Consultation Response from: KC Environmental Health (Pollution & Noise Control)

2024/90272 - Penistone Road/, Rowley Lane, Fenay Bridge, Huddersfield, HD8 0JS

Discharge conditions 17 and 18 (Geo-environmental Ground Investigation, phase 1 and 2) on previous permission 2020/92307 for outline application, including the consideration of access, for erection of residential development (up to 75 units)

Date Responded:
25th March 2024

Client				
HOMES BY HONEY				
Project				
PENISTONE ROAD, FENAY BRIDGE				
Detail				
SITE INVESTIGATION PLAN				
Scale	Dwn	Chkd	Date	Dwg No.
1:1000	A3JF		Jan'24	E23/8060/003

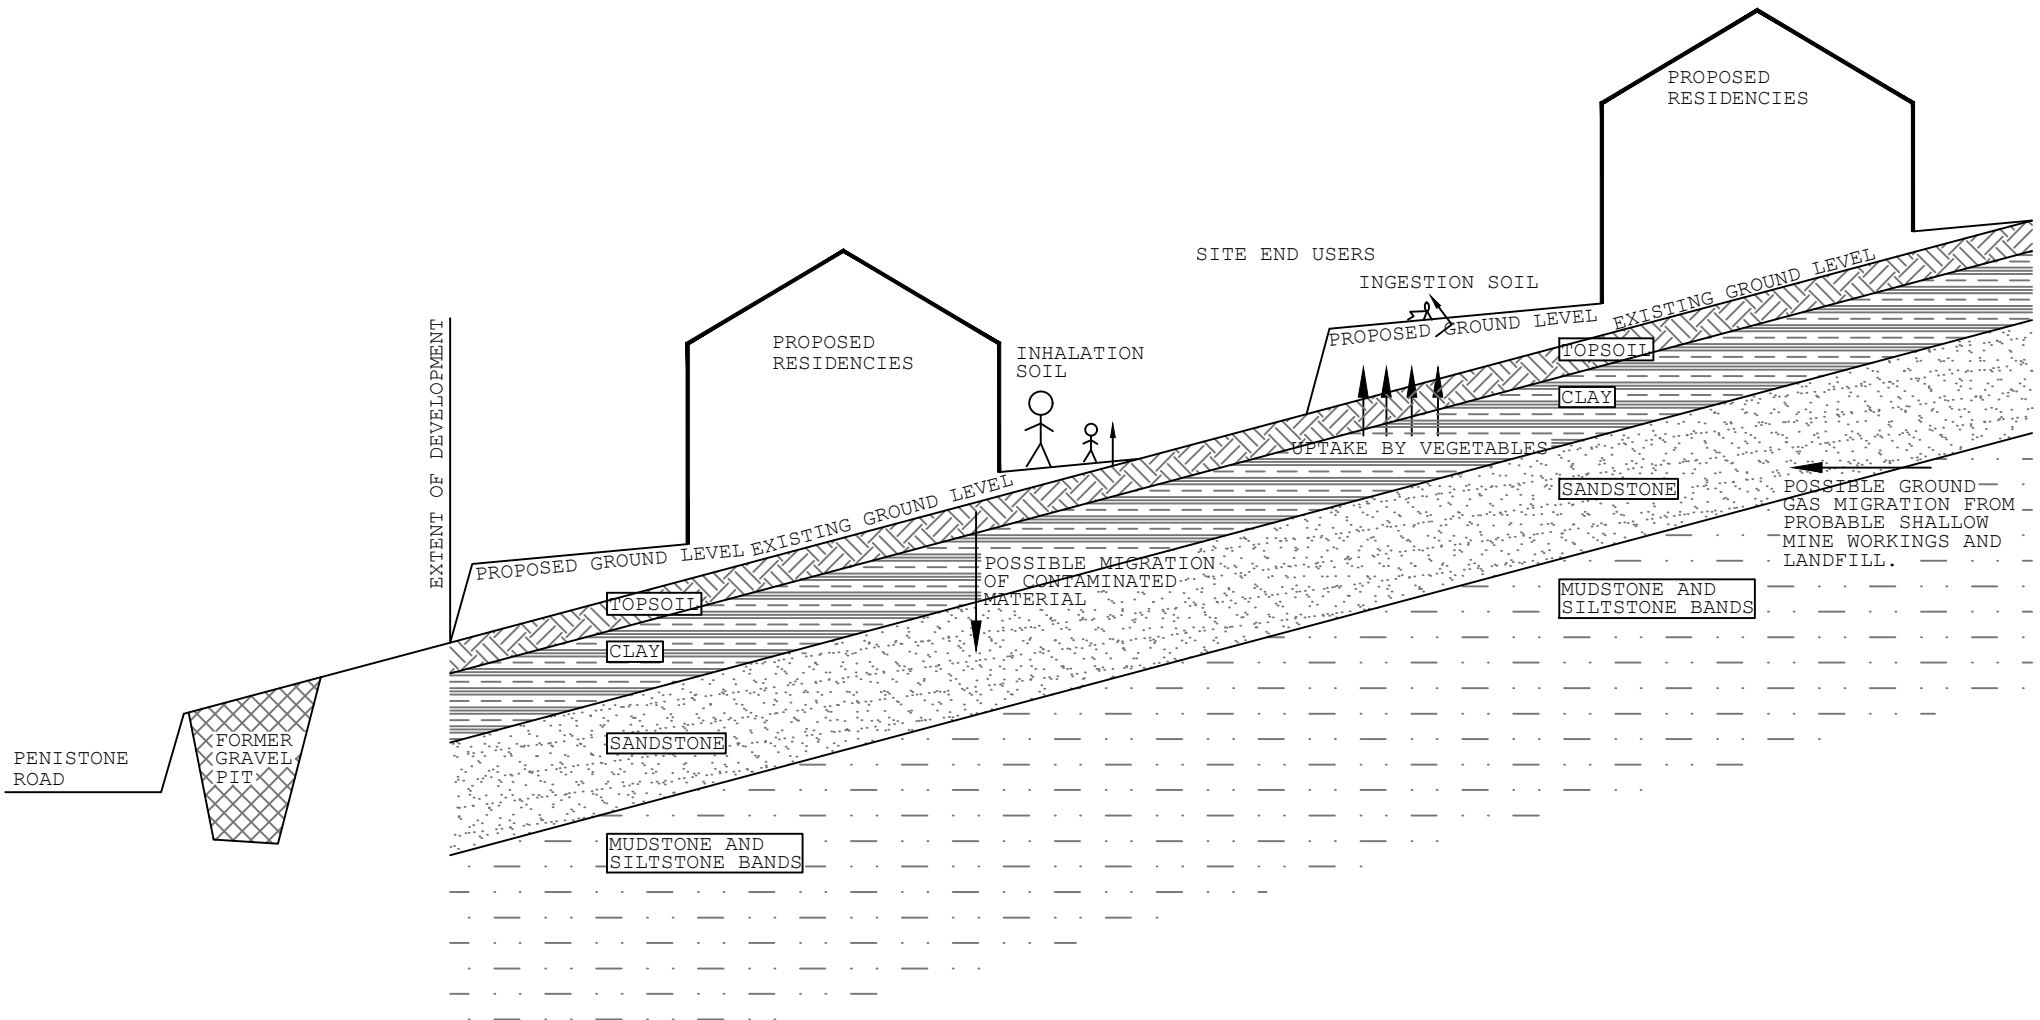
We have read the report provided. The assessment of the risk associated with dibenzo(a,h)anthracene in the soil samples collected from TP101, TP104, and TP105, where elevated levels were observed compared to the chosen assessment criteria value of 0.24 mg/kg, lacks clarity in the report. Although the report suggests a topsoil strip, it does not provide detailed remediation options or specific recommendations regarding the elevated dibenzo(a,h) anthracene levels found in the clay strata at TP104. This was nearly double the assessment criteria value (0.50 mg/kg). Further commentary and clarification are necessary to address this point, especially considering its presence in both topsoil and clay layers.
